June 17, 2024

El Paso County
Planning & Community Development Department
2880 International Circle, Suite 110,
Colorado Springs, CO 80910

**Re: *Townhomes at Western PPR-24-15 – Site Development Plan Comment Response Letter
MVE Project No. 61203***

TOWNHOMES AT WESTERN
 LOT I, CIMARRON SOUTHEAST
 FILLING NO - 2C
**SITE DEVELOPMENT
 PLAN
 SITE PLAN**

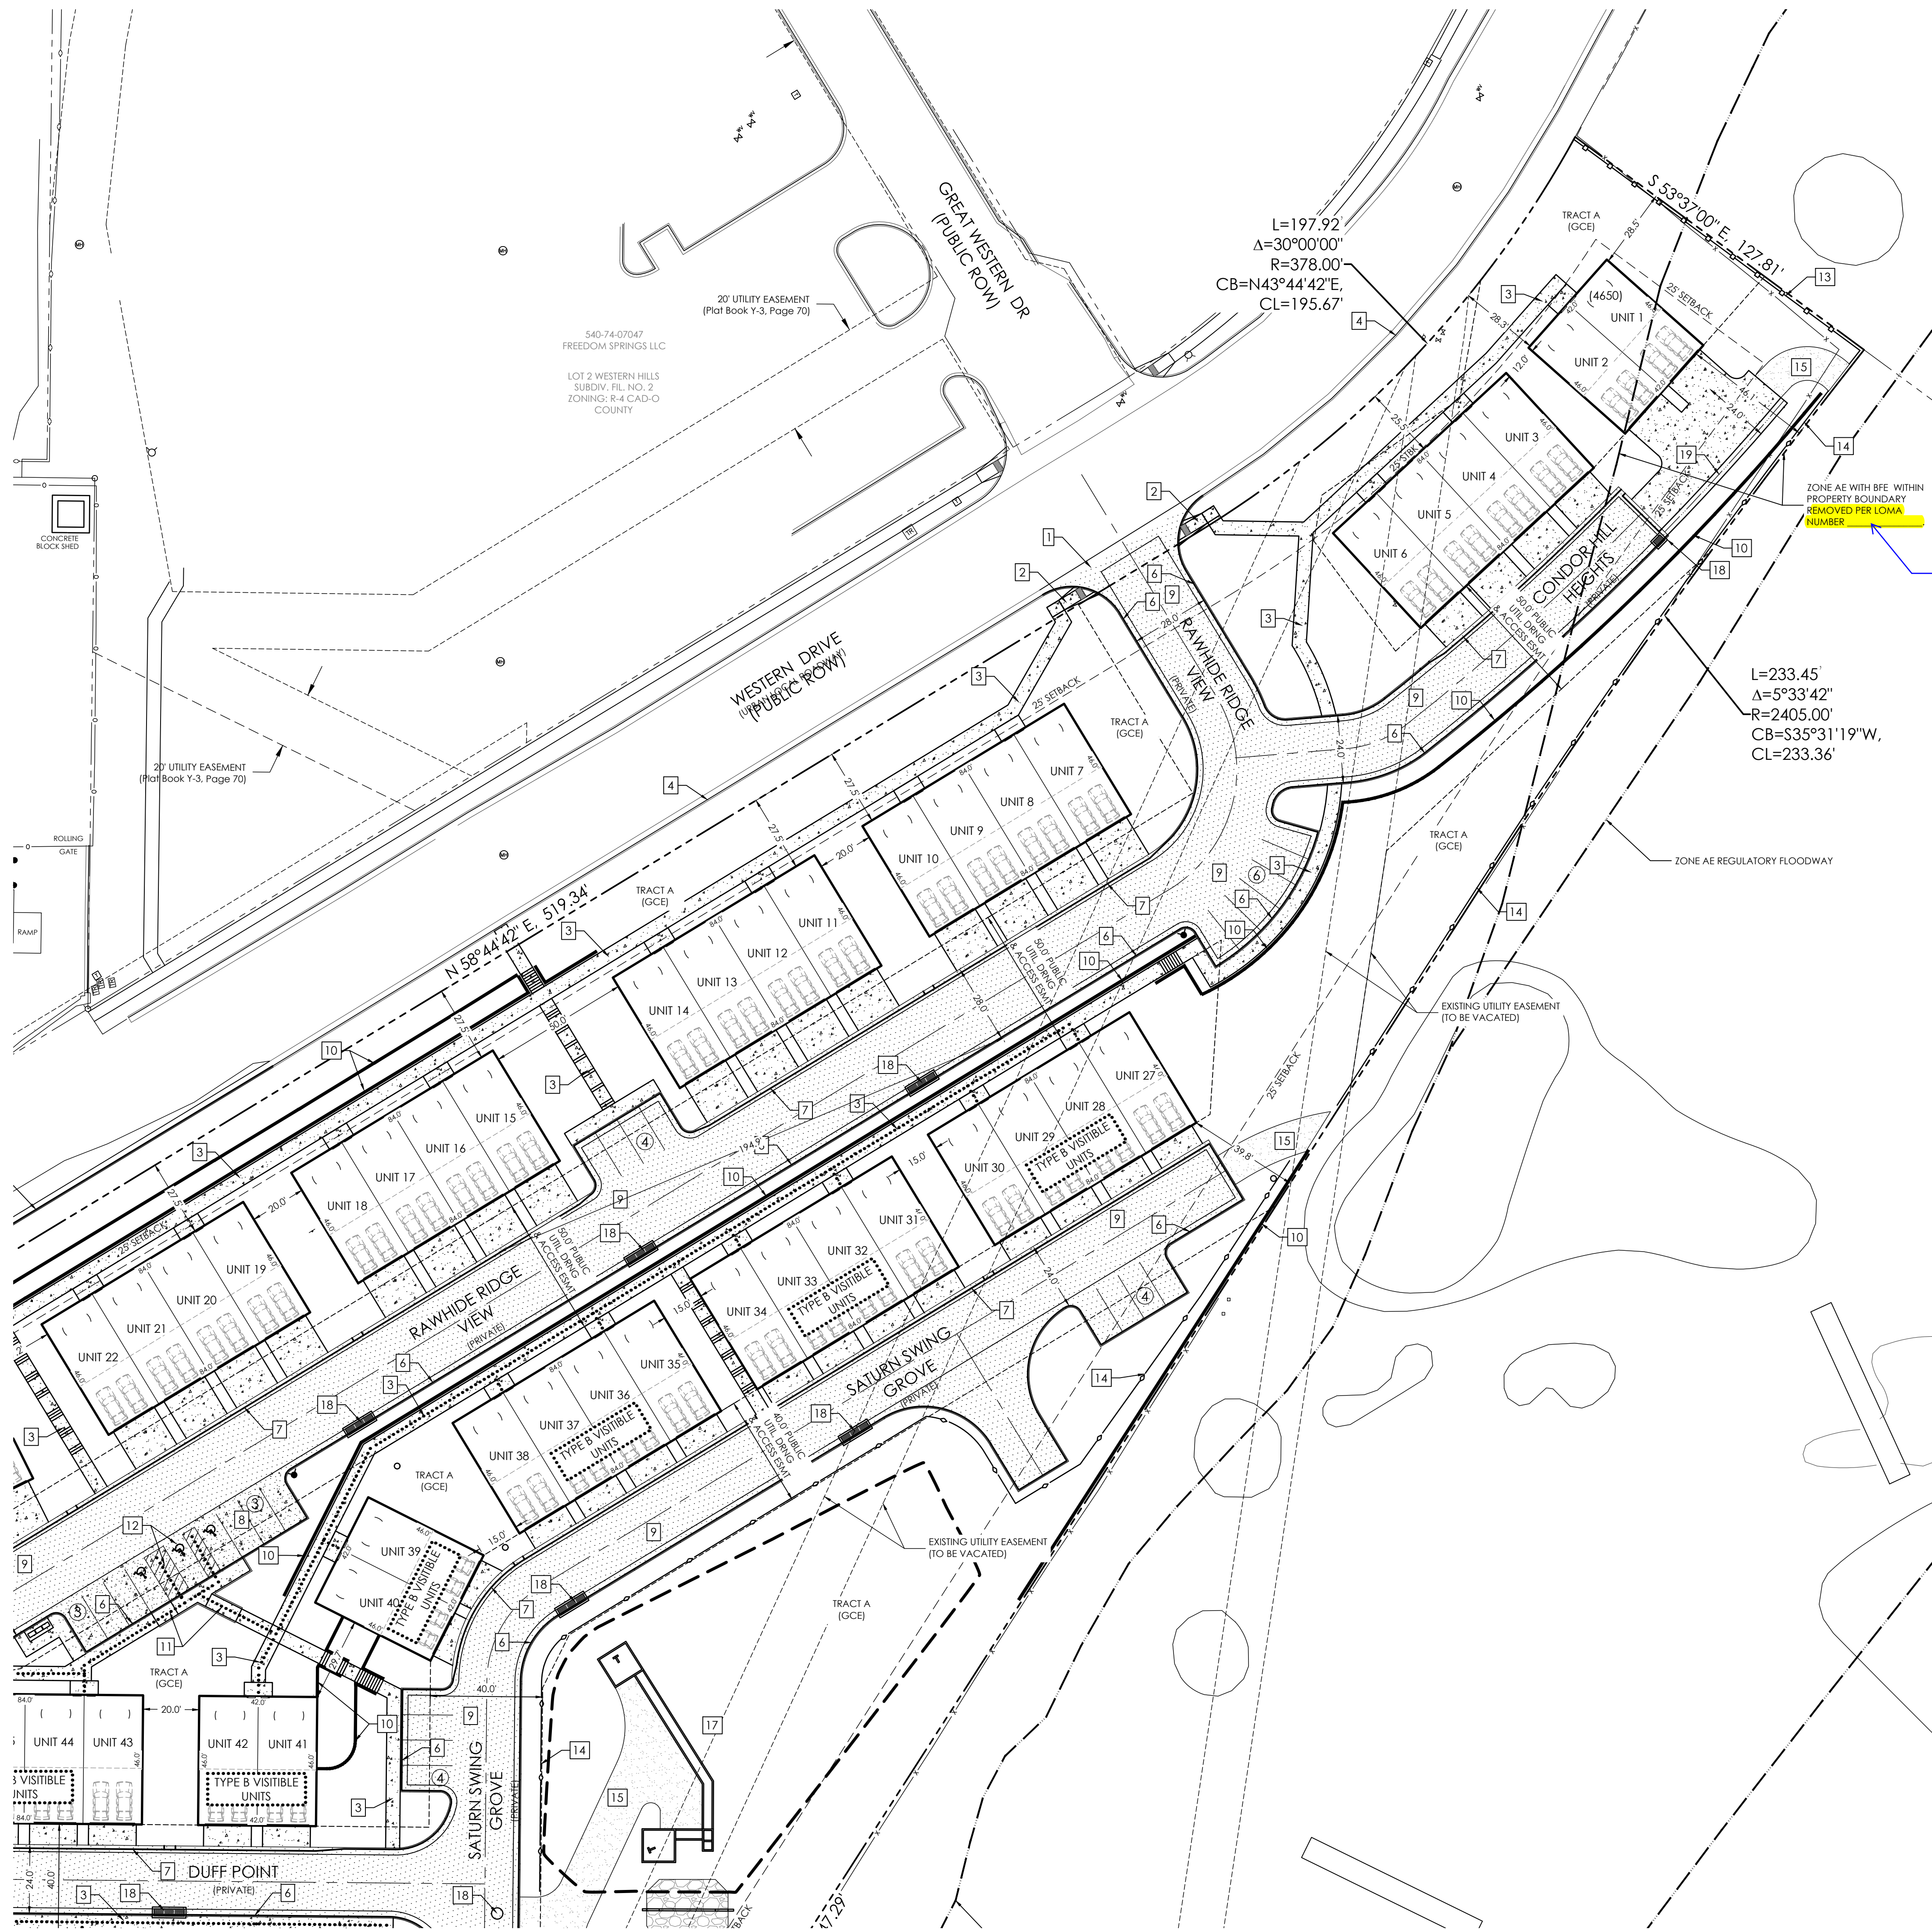
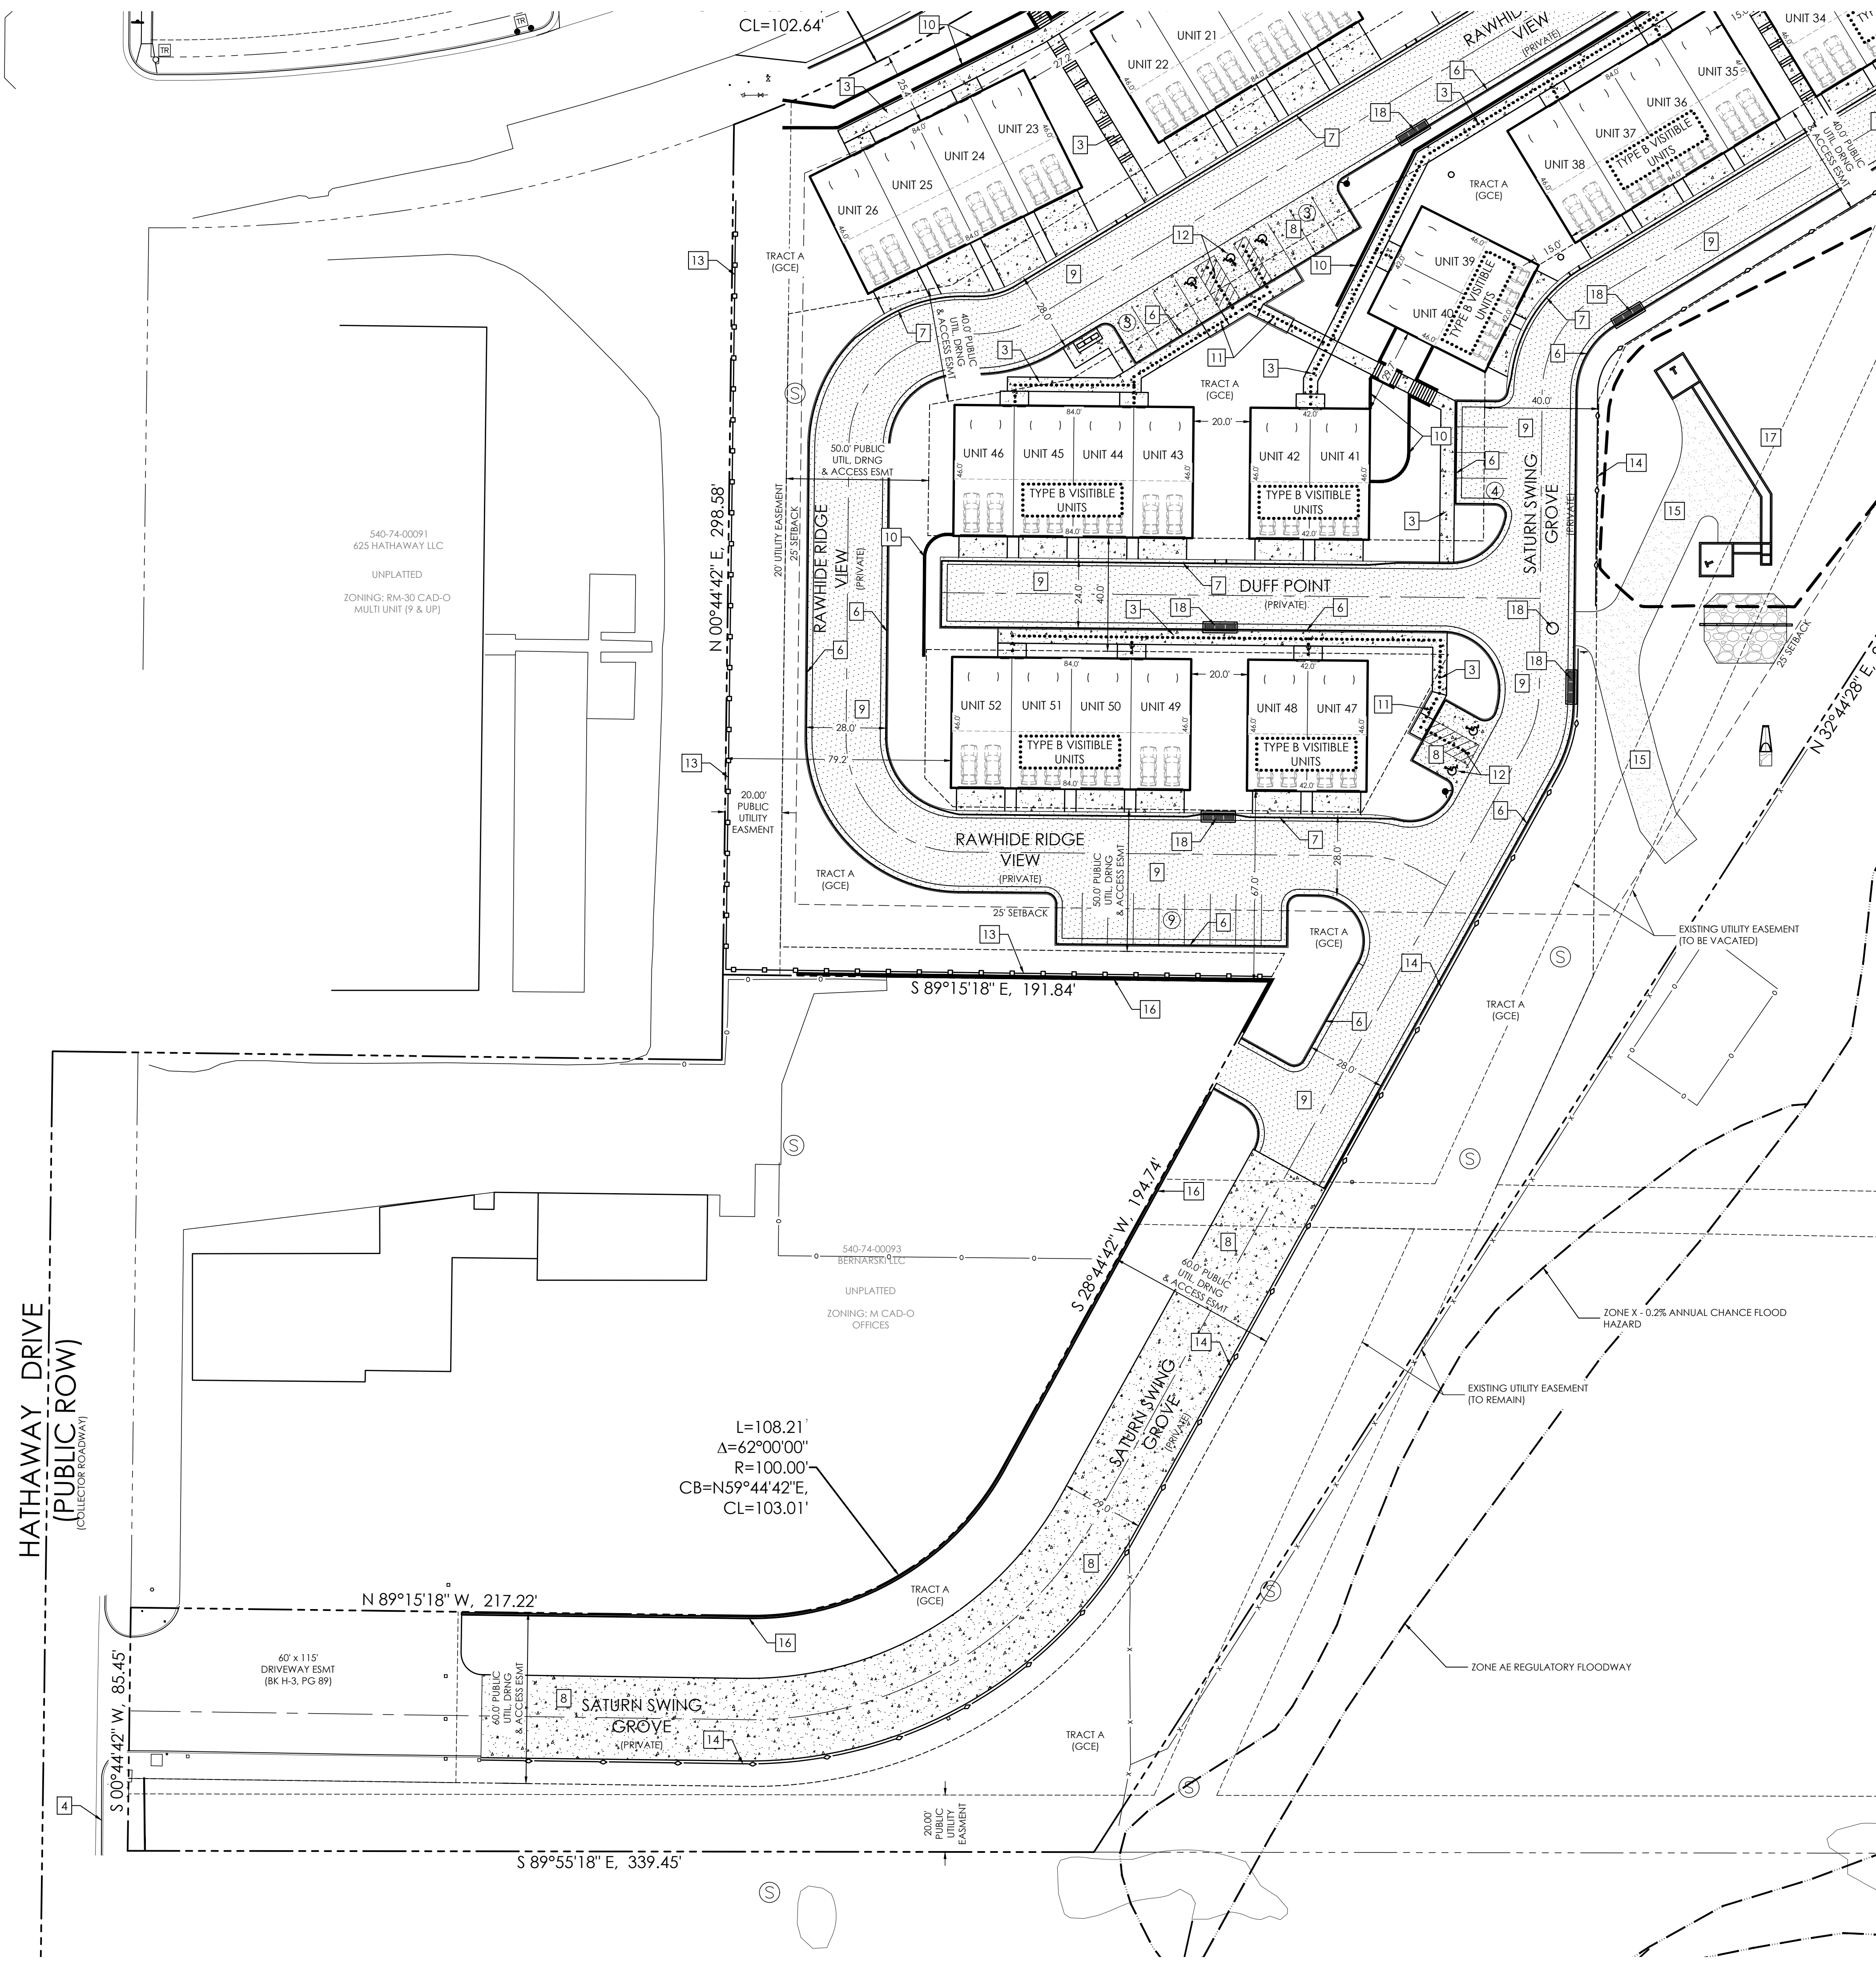
PCD Comment #1: “Please depict the location of garbage receptacles with a graphical depiction of the screening mechanism.”

MVE Response - Trash collection shall be via individual collection bins stored in each unit. There is no common collection point or communal garbage receptacles in this development as was done in a prior similar project. This note was added to the plan. We discussed this in our 6/5/2024 meeting and agreed on the resolution.
